DEVELOPMENT REVIEW BOARD - HYDROLOGY SECTION
 James D. Hughes, PE, Project Engineer | 505-924-3986 jhughes@cabq.gov

DRB Project Number: 1010327 Hearing Date: 5-24-2017

Project: Penny Addition Agenda Item No: 10

**CITY OF ALBUQUERQUE
PLANNING DEPARTMENT
May 24, 2017
DRB Comments**

**PLAT OF
LOTS 1-A AND 1-B
NORRIS AND MARGARET PENNY ADDITION**
(BEING A REPLAT OF LOT 1, NORRIS AND MARGARET PENNY ADDITION)

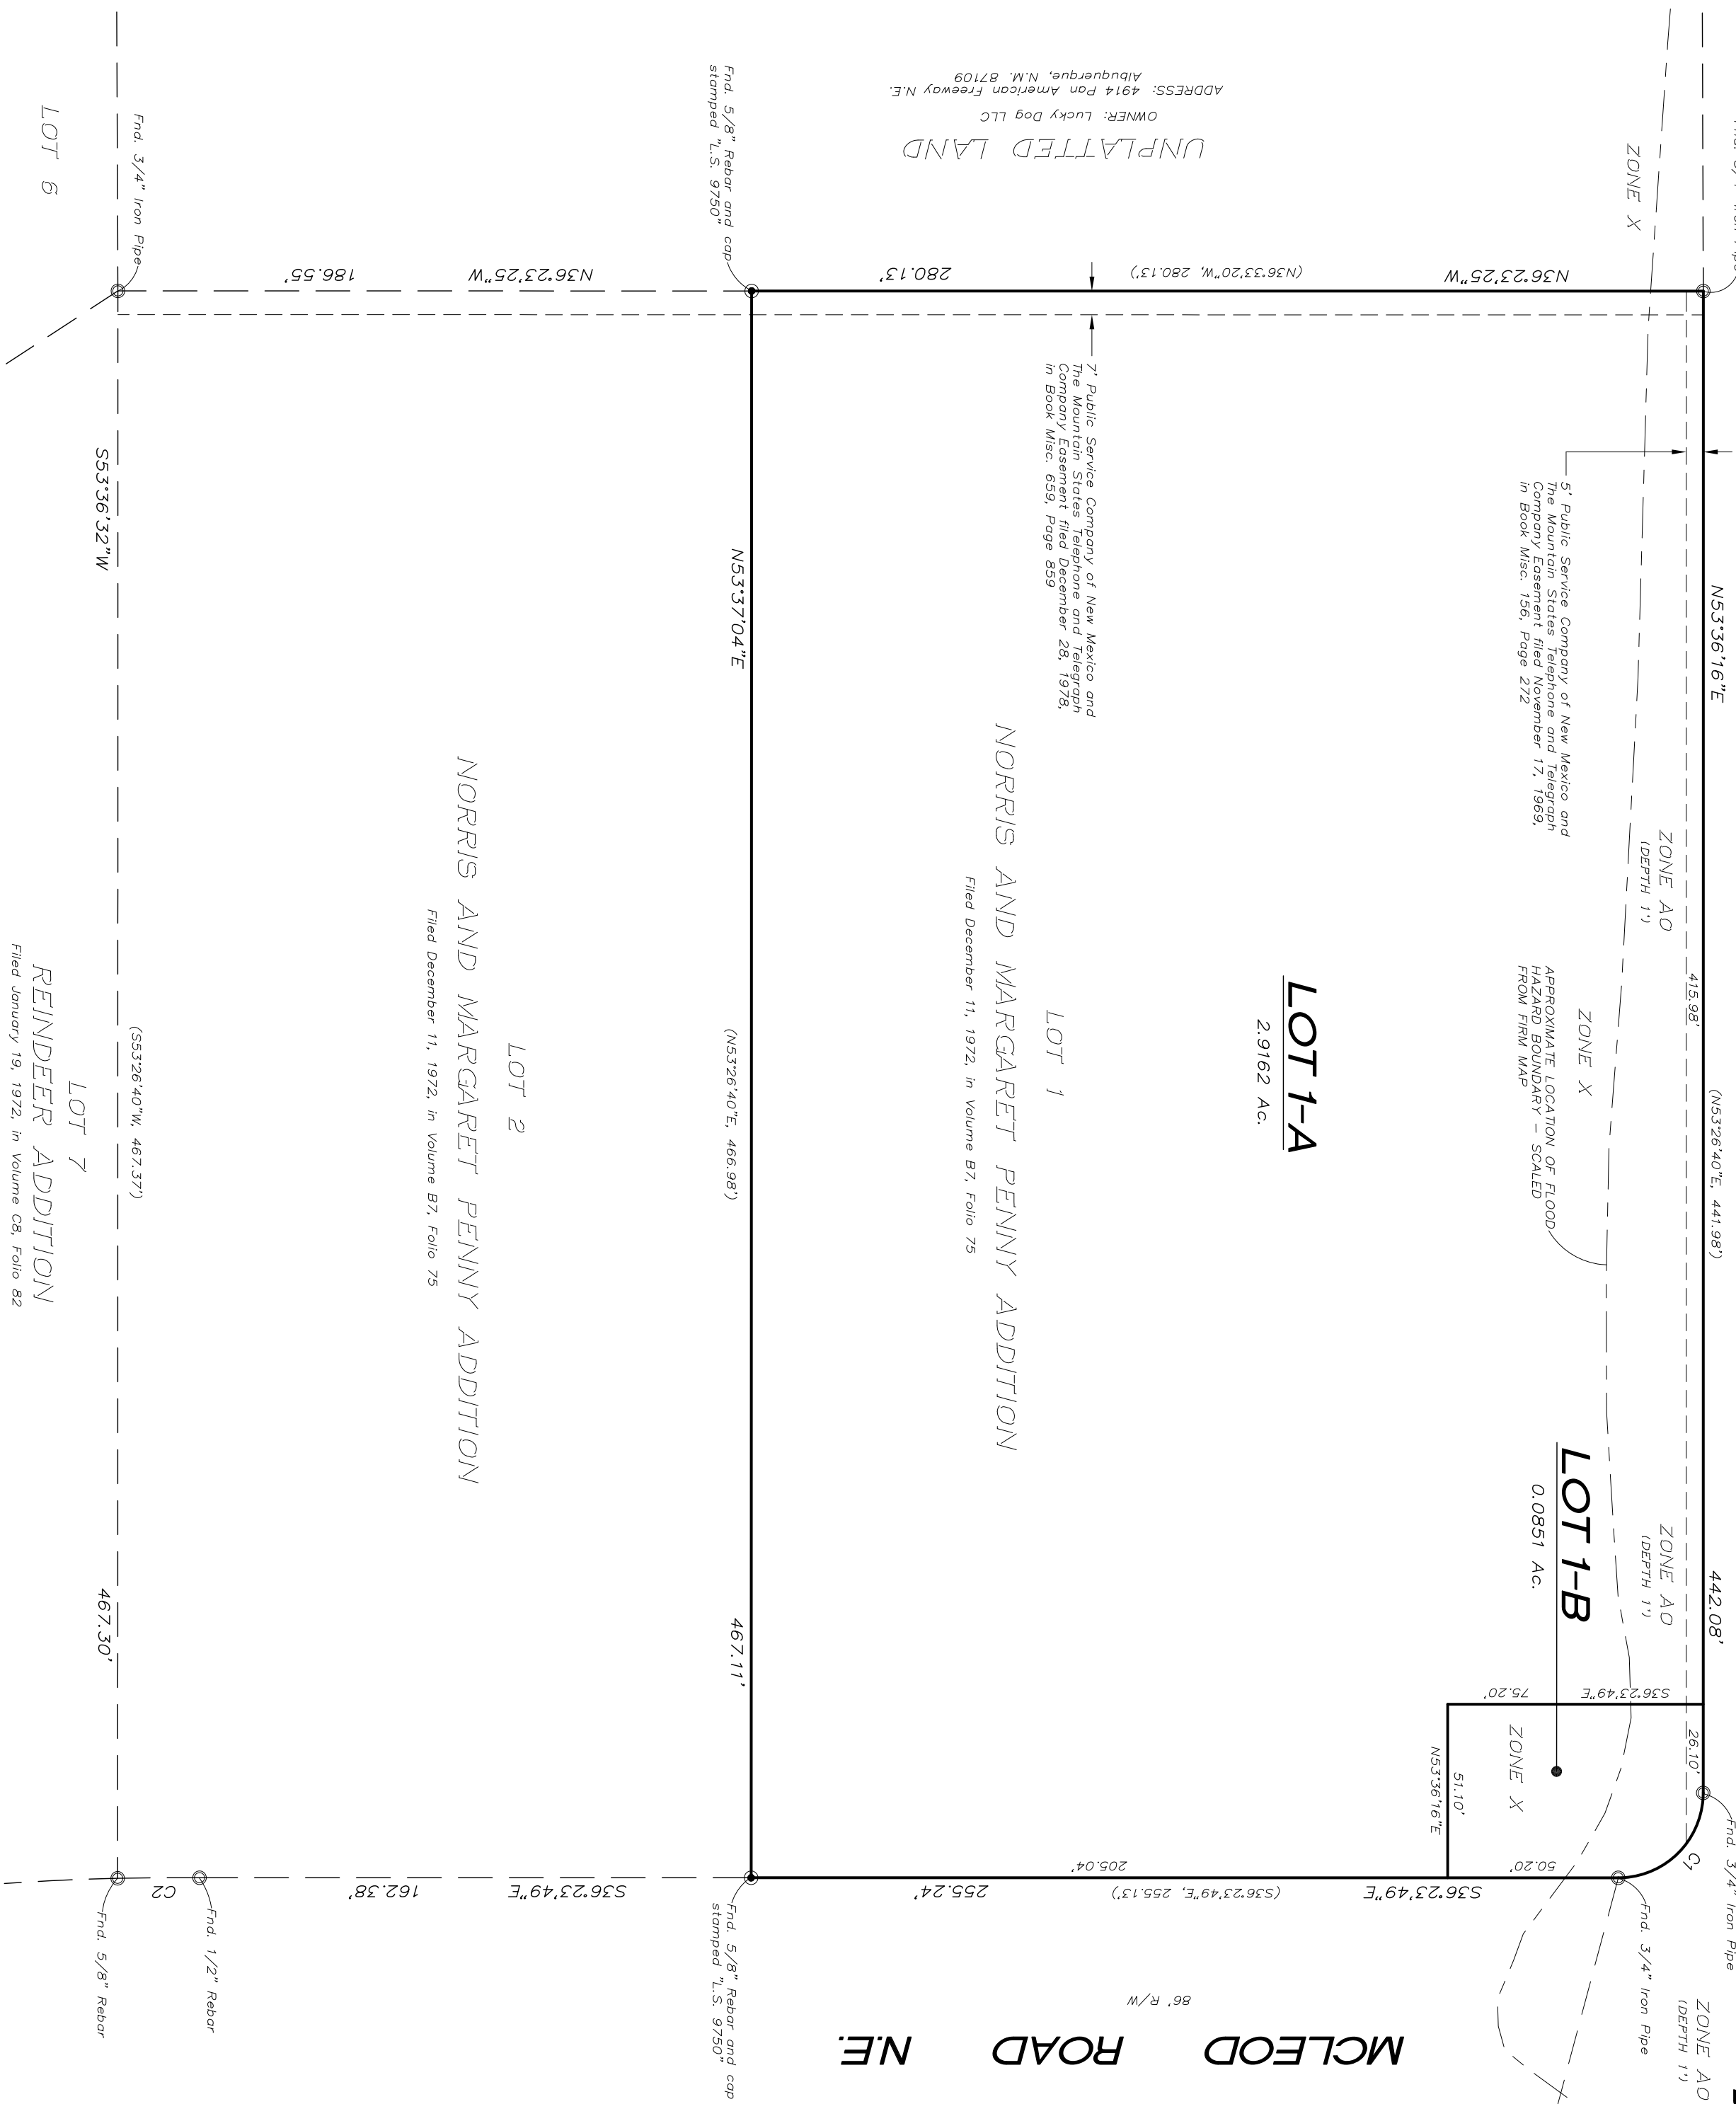
- Cross lot Drainage easement needed on lot 1A for the benefit of lot 1B.

It appears several easements are needed for access and drainage – refer to comments from Transportation Development and Hydrology.
